# CITY OF ALBUQUERQUE

September 20, 2021

**Re: Sigma Chi Apartments**  
**1815 Sigma Chi Road NE**  
**Traffic Circulation Layout**  
Architect's Stamp 09-20-2021 (J15-D102)

REVISION DATE
DATE 09-22-2021
SHEET NUMBER AS-1.0

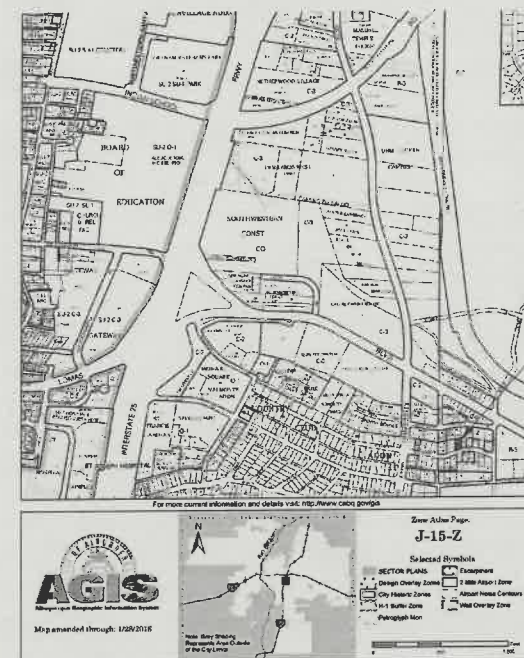
1. Listed are the number of parking spaces required by the IDO as well as the proposed number of parking spaces including bicycle and motorcycle parking. Coordinate/discuss with Zoning. **Status of Motorcycle Parkings(Explain)?**

2. Street name on Site Plan will need to be provided.
3. In accordance to AGIS, A sidewalk easement will be needed for sidewalk and curb & gutter located on private property. Please address this concern of property line location on AGIS versus Site Plan.

4. Driveway entrance will need to be ADA complain. A construction note to remove and replace driveway with new needs to be added to Keyed Notes and the new width provided.

5. Keyed Note 6: shown on drive aisle! What is going on? Explain
6. Keyed Note 25: Explain this note because if you need a mini work order by Water Authority to can be done with a note added.

7. Site Plan: shown on plan are 3 bumper symbols on parking stall. Please address.
8. Identify the street width and ROW width on Sigma Chi Road.
9. The minimum parking stall dimensions are:

10. The ADA accessible spaces must include an access aisle. **Van accessible aisles should be 8ft wide (you have provided only 7'-8")**; all others should be 5ft wide.

11. **Motorcycle parking spaces (Status?)** shall be designated by its own conspicuously posted upright sign, either free-standing or wall mounted per the zoning code. **Label pavement MC.**

12. Per the IDO, a 6 ft. wide ADA accessible pedestrian pathway is required from the public sidewalk to the building entrances. Please clearly show this pathway and provide details.

13. Per DPM, a 6 ft. wide ADA accessible pedestrian pathway is required from the ADA parking stall access aisles to the building entrances. Please clearly show this pathway and provide details.

14. **Curbing should be installed to delineate landscape, parking, and pedestrian ways and identify points of access. Please call out detail and location of barrier curb.**

15. Please specify the City Standard Drawing Number when applicable.
16. Add a note stating "All broken or cracked sidewalk must be replaced with sidewalk and curb & gutter." A build note must be provided referring to the appropriate City Standard drawing (2430 & 2415A).
